Our Reference: CLA.D5.OS.A.C

Your Reference: EN010106

Comments on the Applicant's D4 submissions

This document sets out the comments on the Applicant's Deadline 4 (D4) submissions by Cambridgeshire County Council (**CCC**). The tables below set out the document in question that the Council is commenting on, together with the relevant paragraph or reference number.

SWEPT PATH ANALYSIS - HGV - RIGHT TURN FROM LA HOGUE ROAD - ENTRY

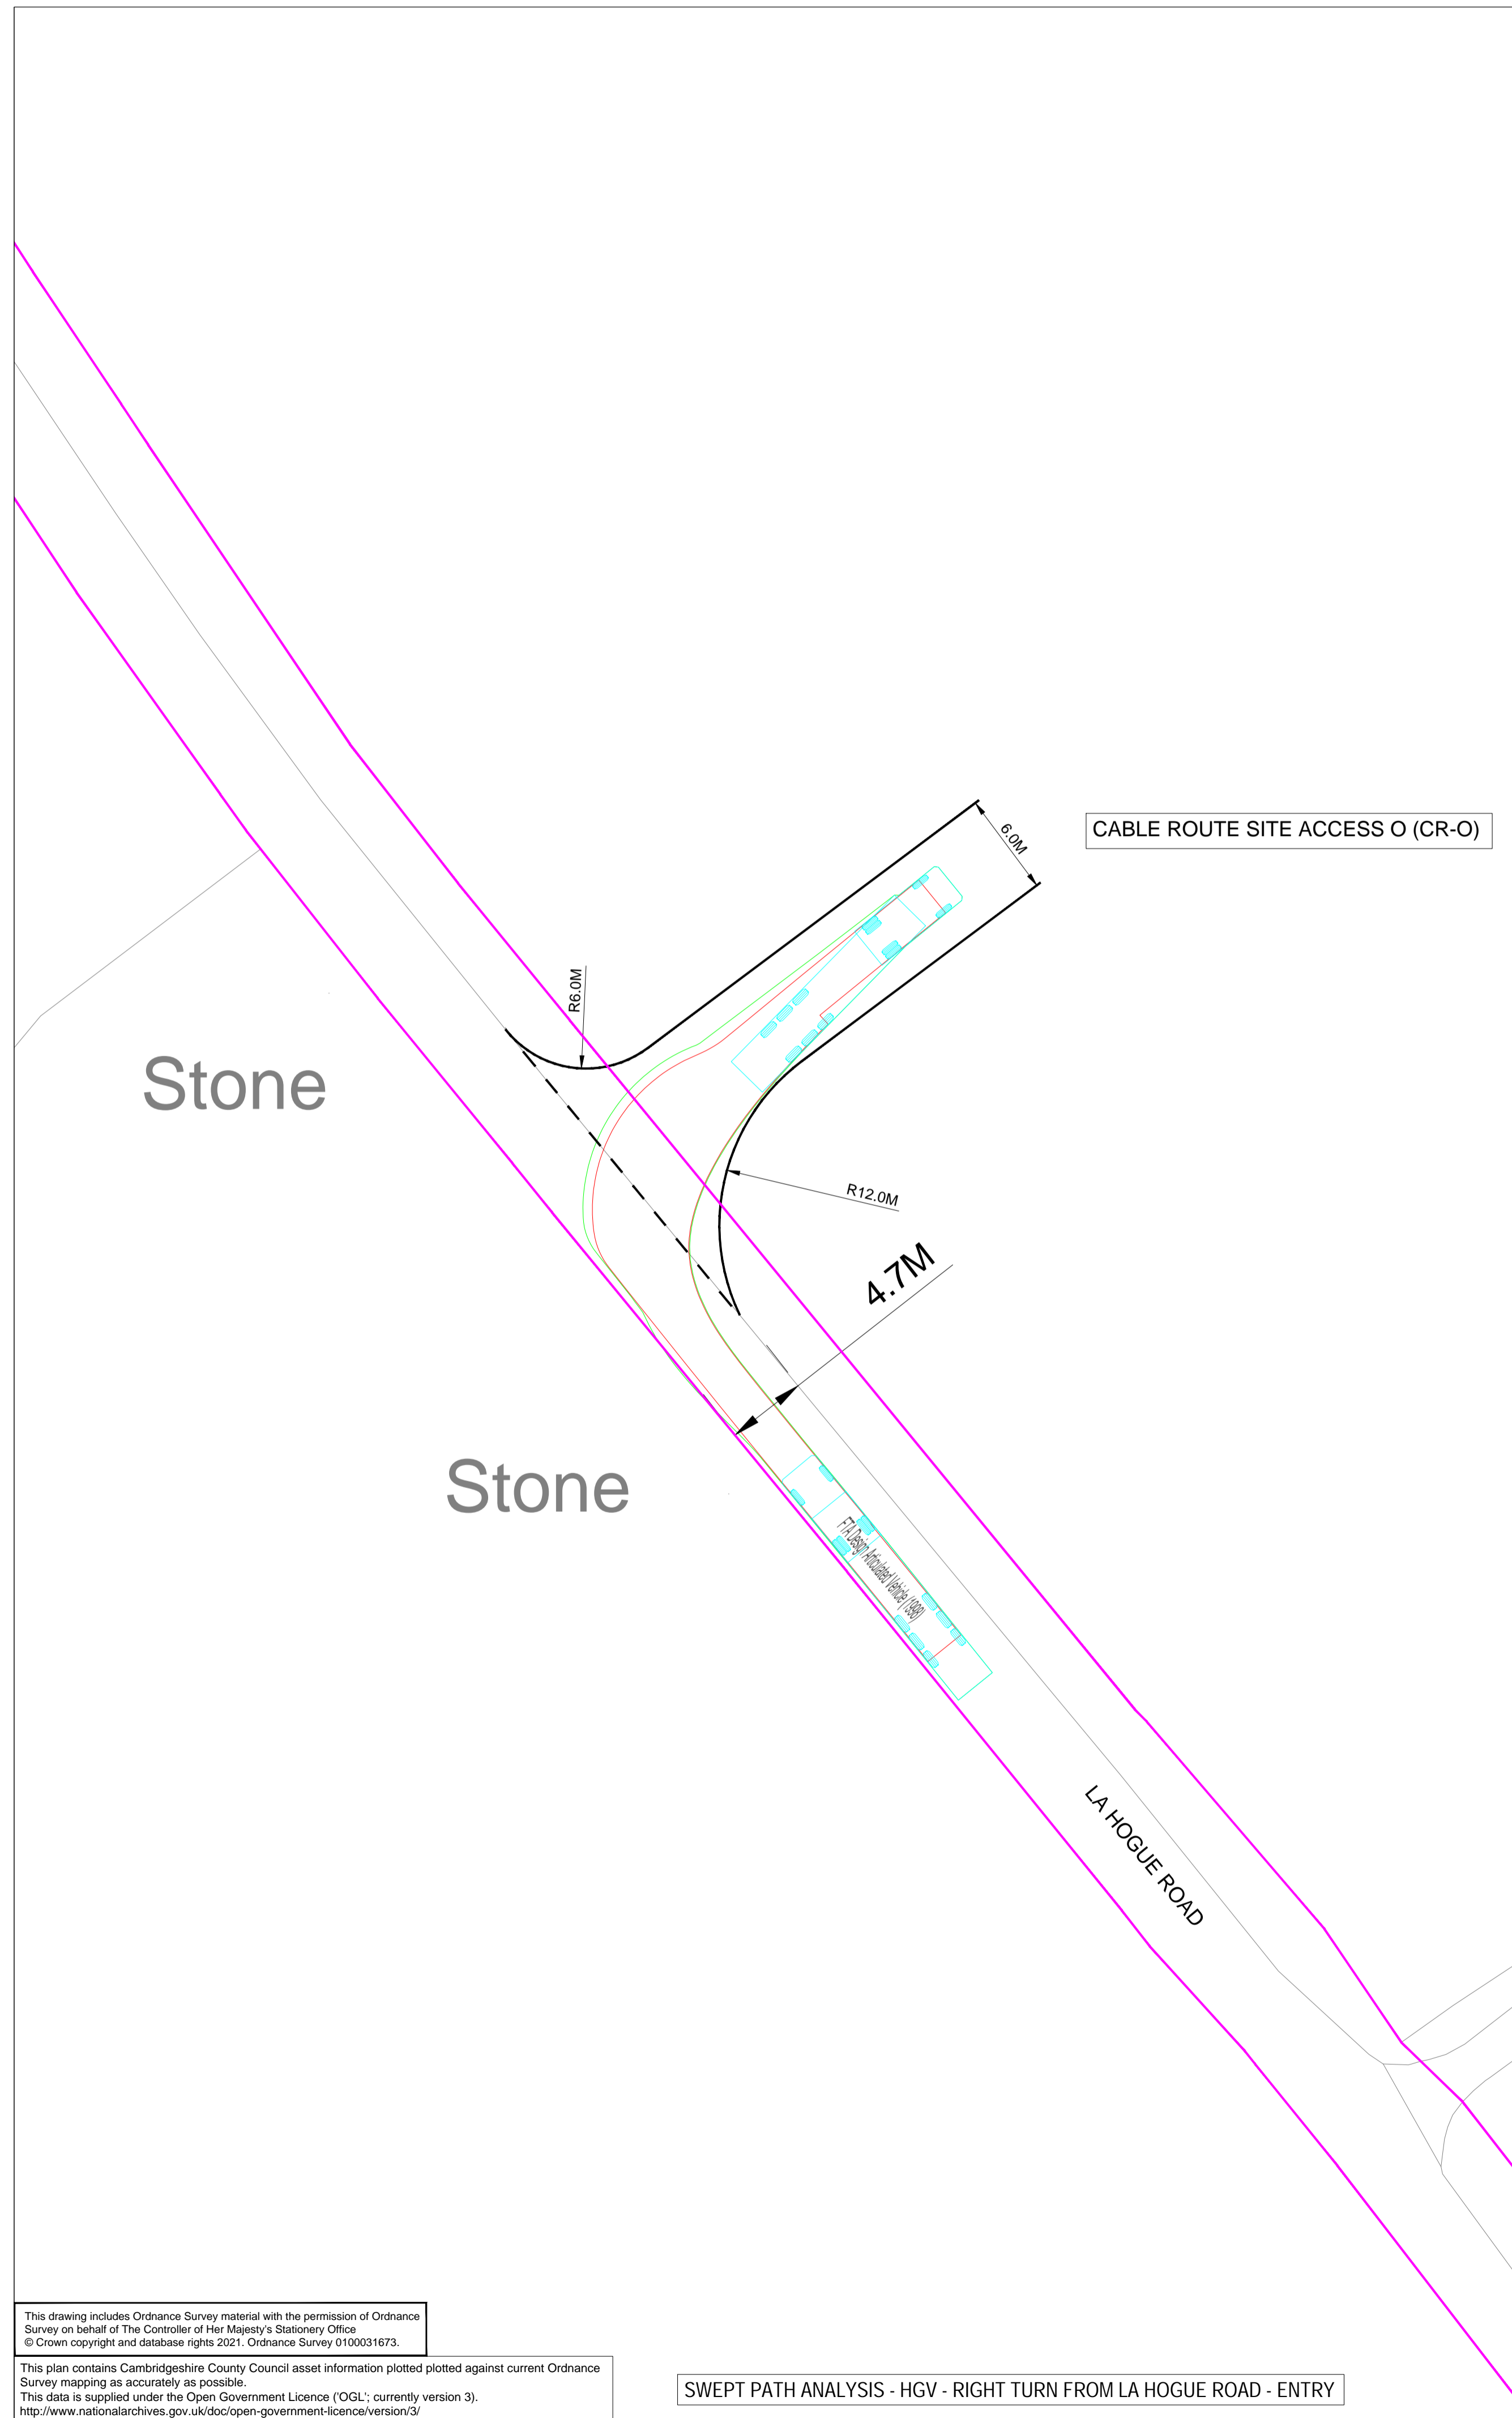
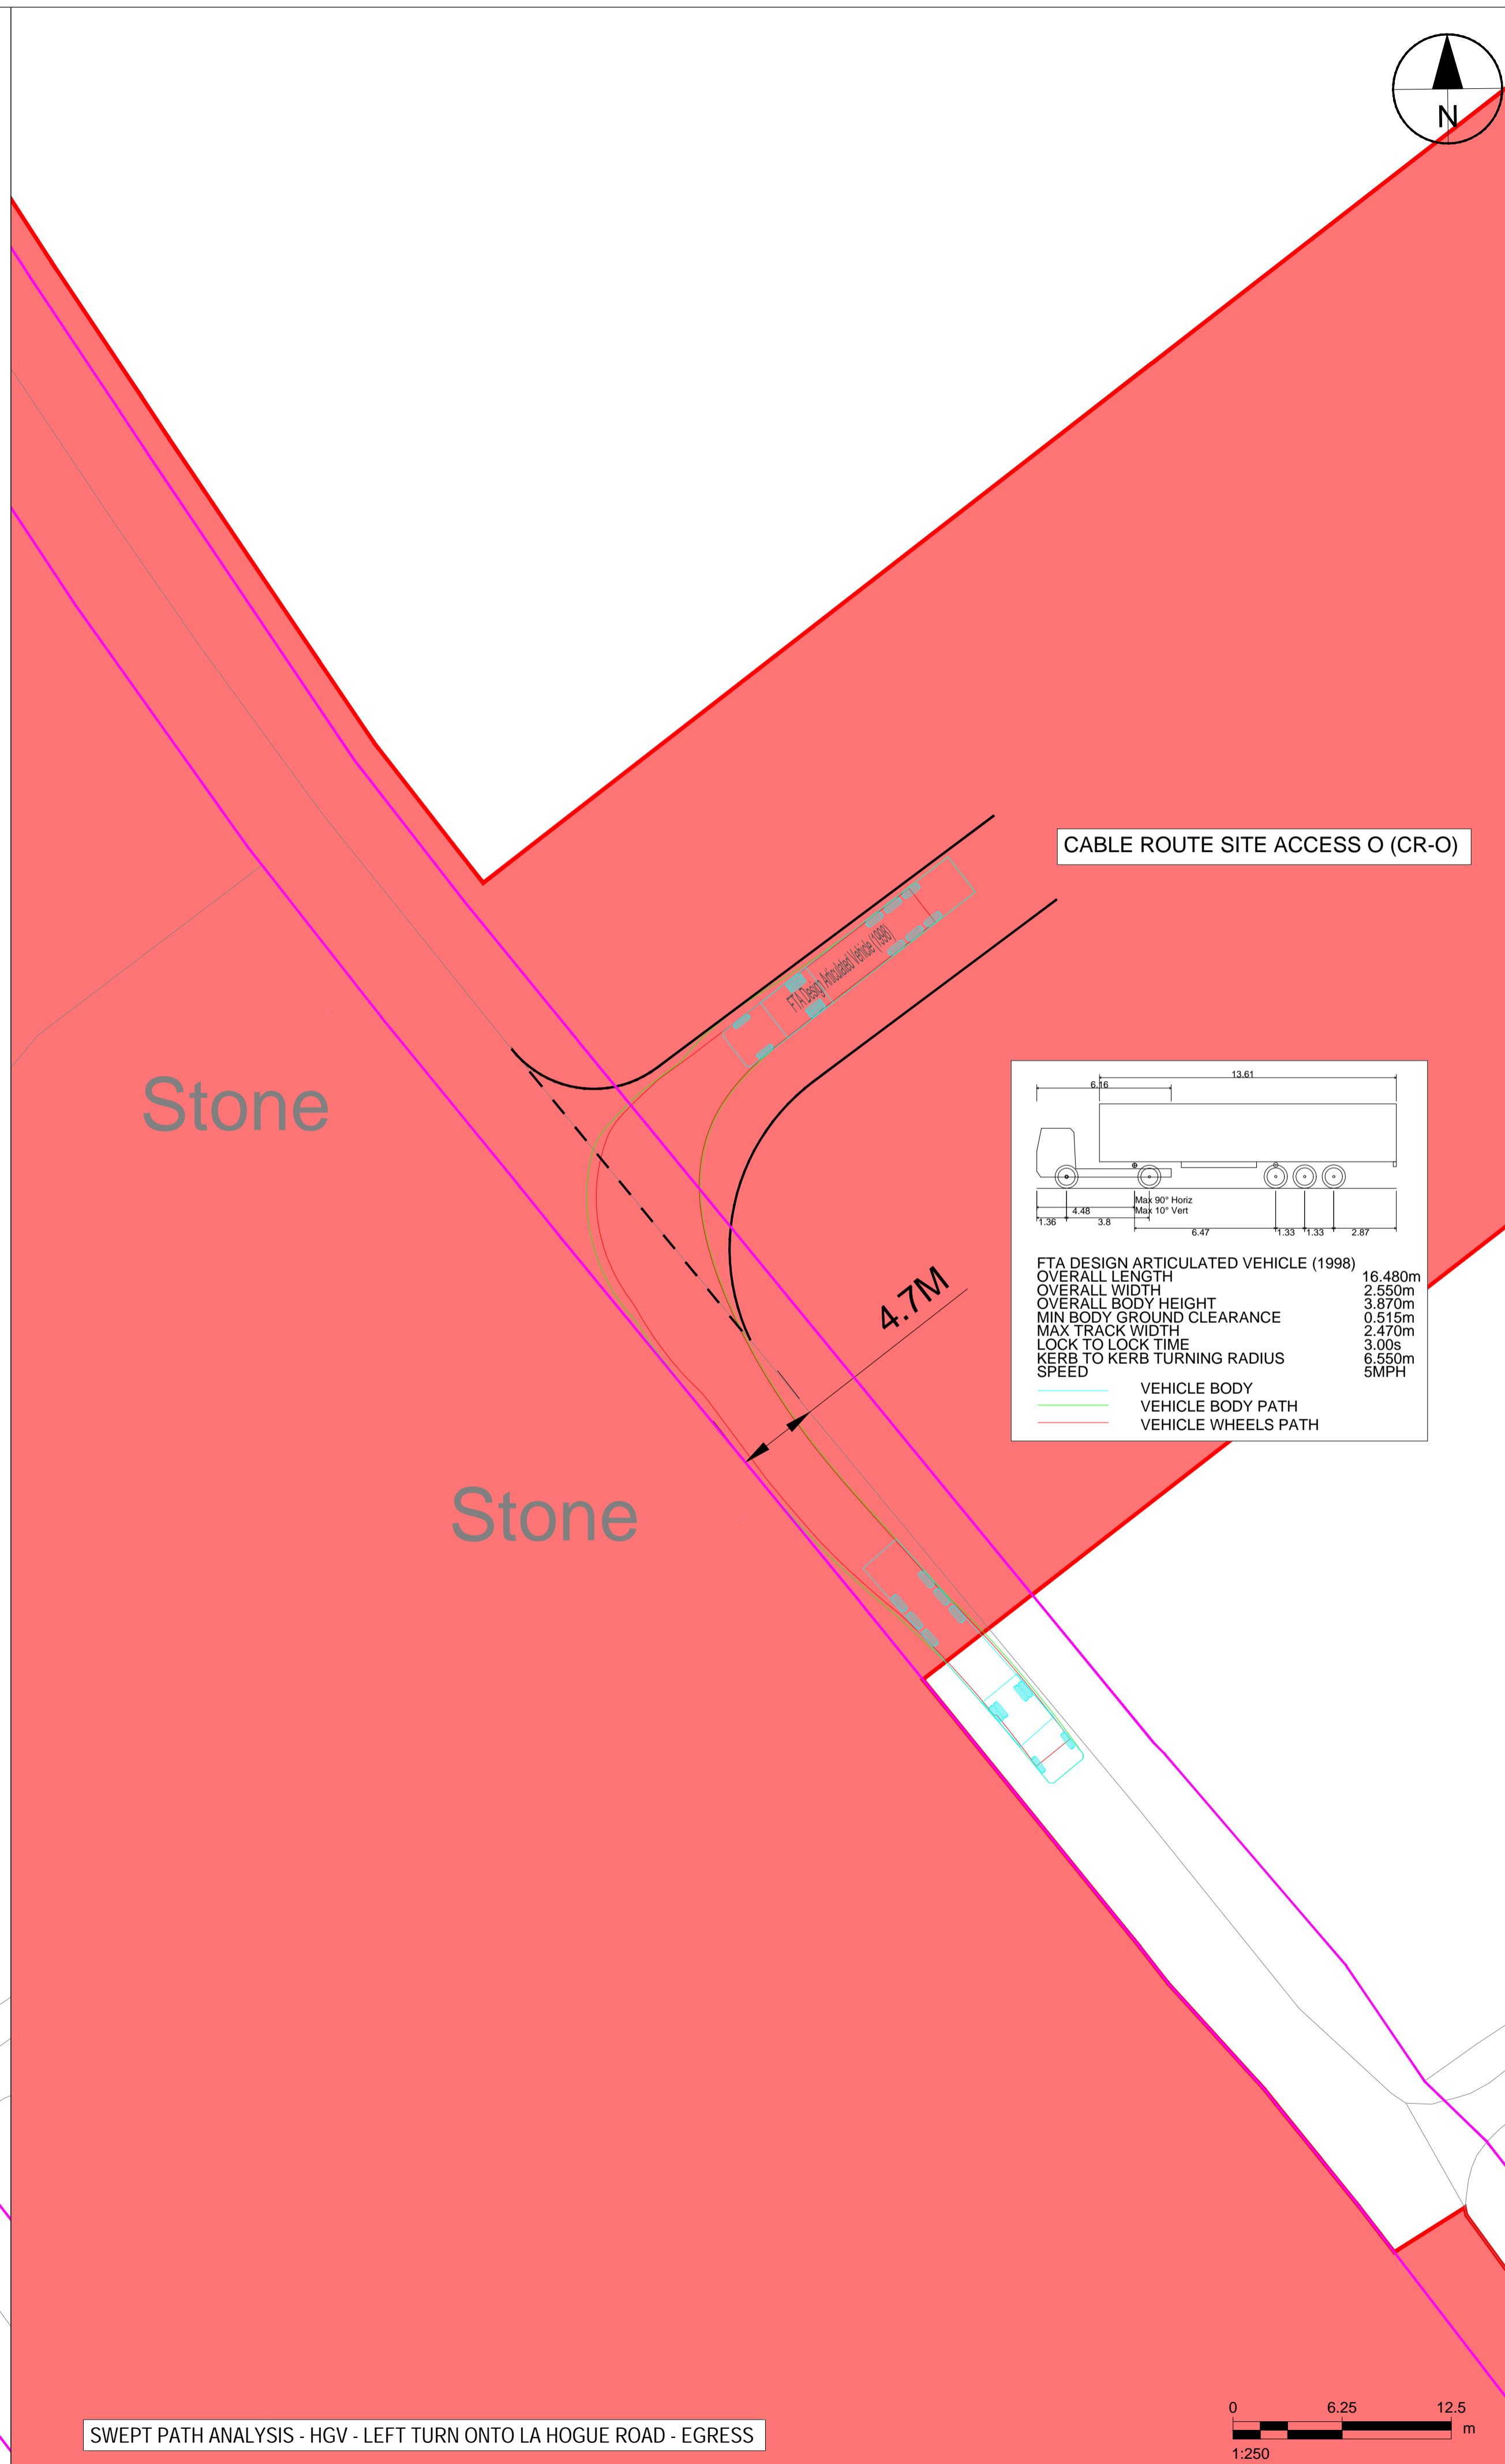
Site access and Crane routes – Deadline 2 submission: Q1.10.45	Para 2, Page 27	<p>While discussions have been ongoing regarding the La Hogue Road passing bays, safe use by HGVs has not yet been established. The Applicant should be invited to provide a fully independent Stage 1 Road Safety Audit, having first received approval for the Audit Brief and proposed Audit Team from the local highway authority as Overseeing Organisation. Any problems identified in the audit should then be resolved to the satisfaction of the local highway authority prior to determination.</p>
Site access and Crane routes – Deadline 2 submission: Q1.10.45	Para 2, Page 28	<p>The Applicant indicates that they do not anticipate large loads being required to use the accesses during the operational phase; it remains unclear what activity can be anticipated in the event that maintenance is required. This would presumably include delivery of some materials and plant, which will share many accesses with existing ongoing agricultural use. With regard to Article 5(3), Environmental Statement assessments are not considered appropriate in determining whether the impact of proposed use during the operational phase would be detrimental to highway safety.</p>
